Planning Application No: 3/2022/0743

Proposal: Proposed construction of a single storey twin garage to the rear.

Location: 26 The Sands Whalley BB7 9TL

SHEET:  
PROPOSED SITE PLAN

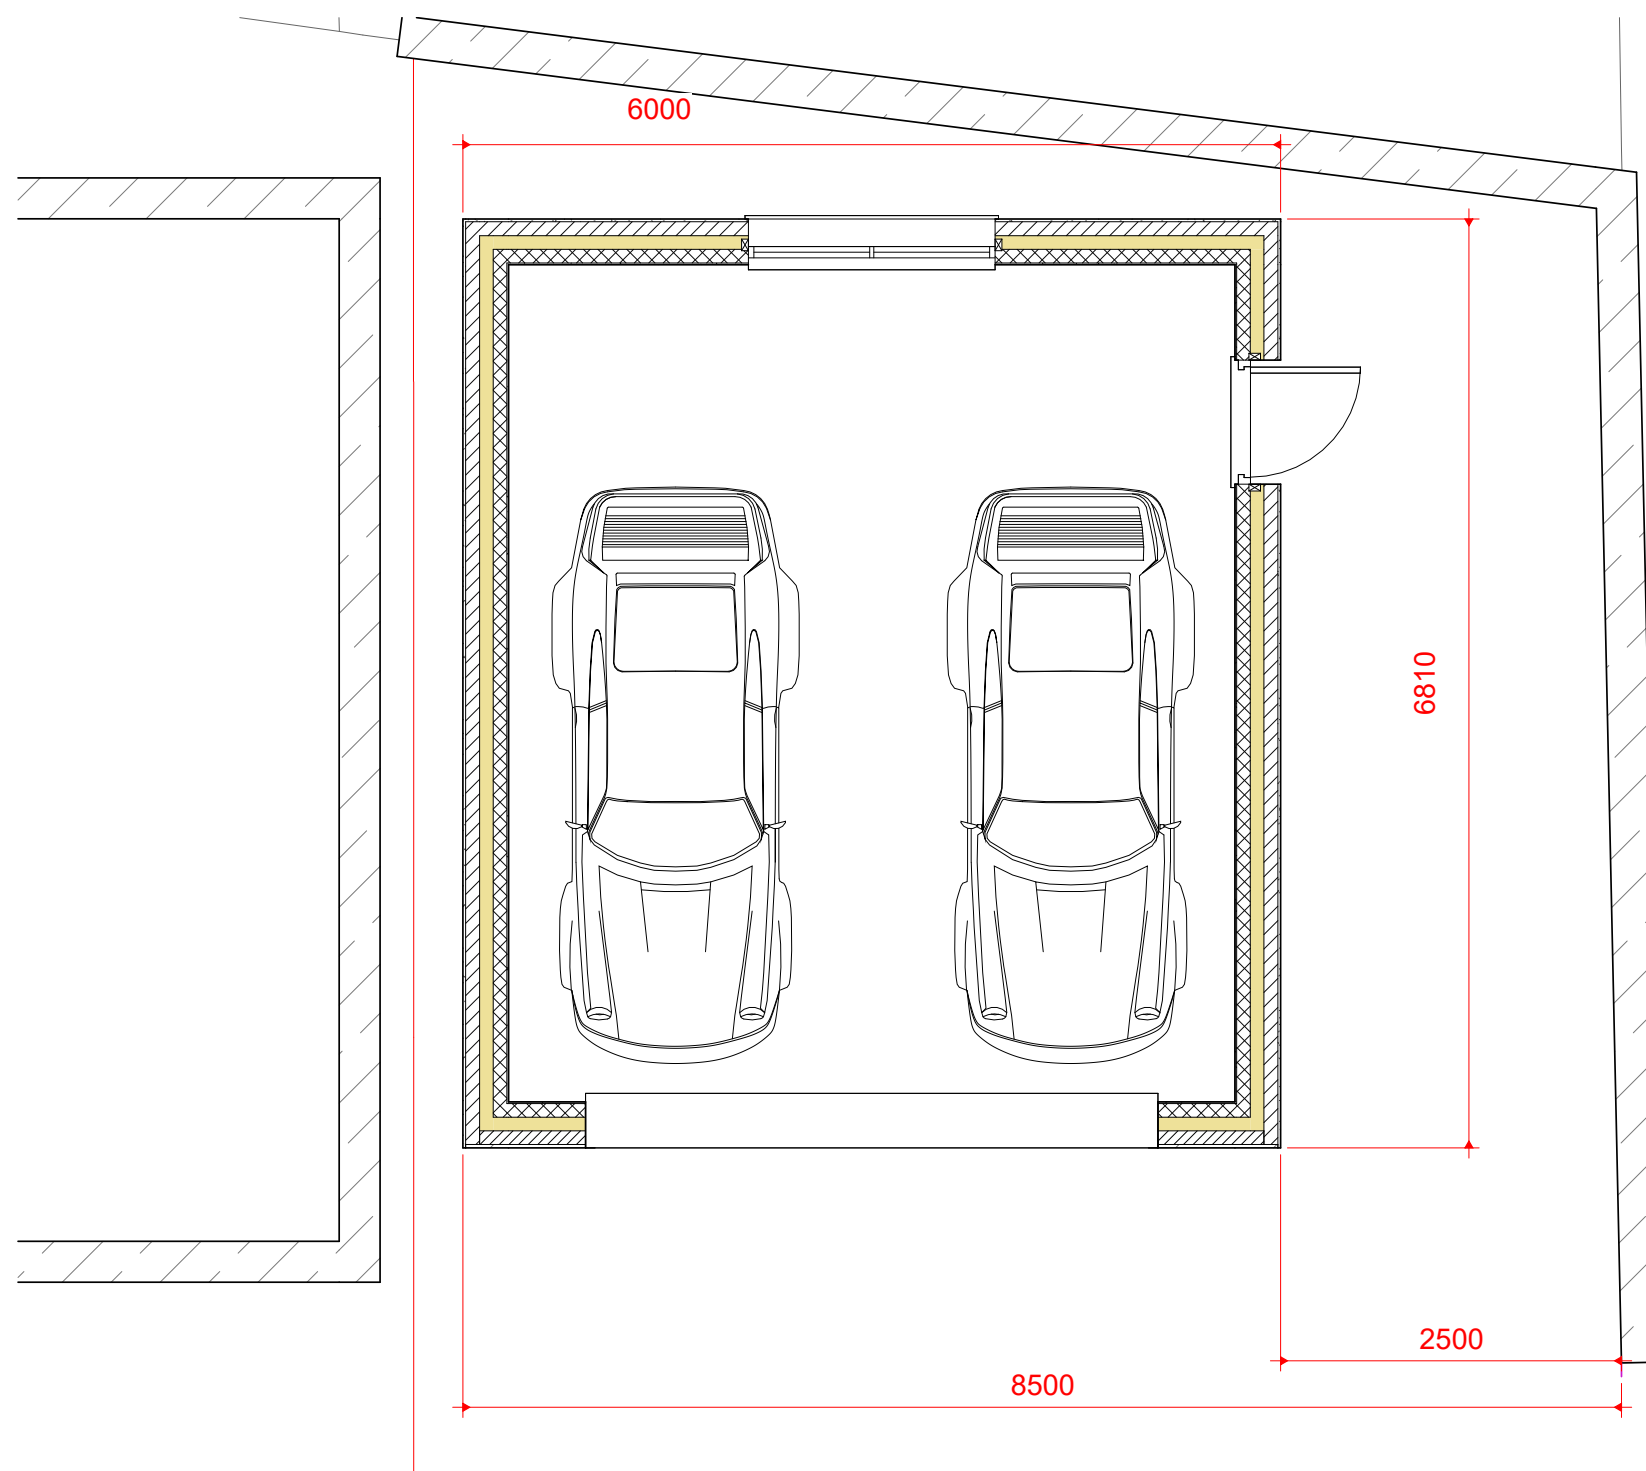
It is noted that the area for the proposal is currently being used for parking. A two-vehicle garage should be 6m by 6m minimum. If the drawing (ref: Proposed site plan, project number PHA/782, 02/08/2022/LW/PH) is amended to show the garage to be 6m x 6m in size then that will provide a 6m clearance from the garage door to any other obstruction. Then this will be acceptable.
